Sent: 15 September 2026 14:03
To: DC Admin
Subject: Planning application 2026/92154

Ref; 12 ,Birch Grove, Woodlands Road Batley WF170RQ

PROPOSED SITE PLAN

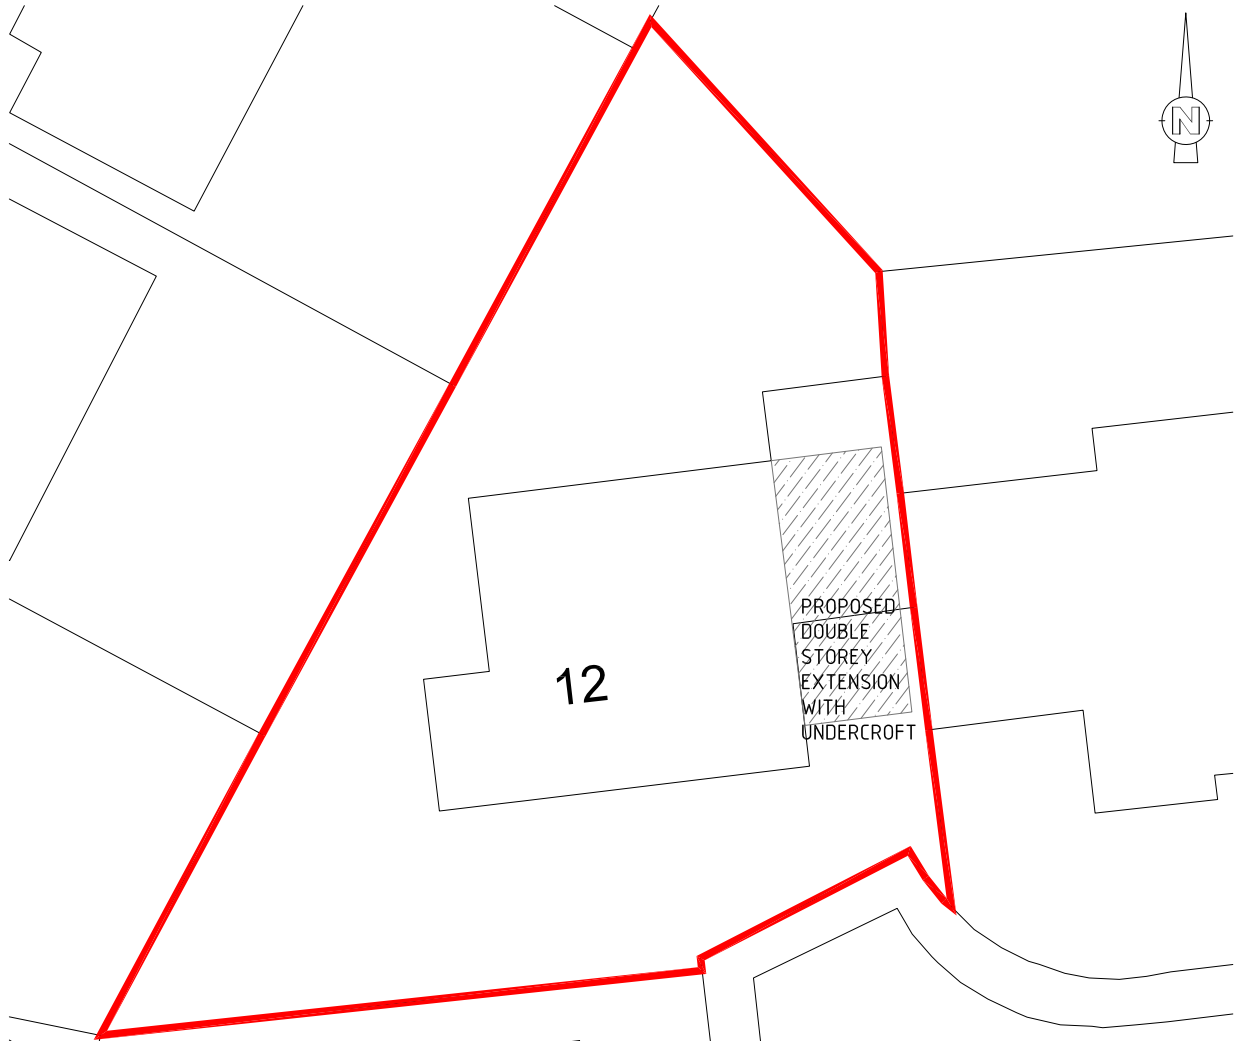
By the demolition of the garage (2 vehicles) and the subsequent shortening of the drive, the problem is the parking of the applicants vehicles.

The proposed plans do not show any areas within this property that are designated for additional parking. At the previous applicants property there are four vehicles on the drive

The approval of this planning application without the provision of extra parking provision would cause problems for all the residents of Birch Grove
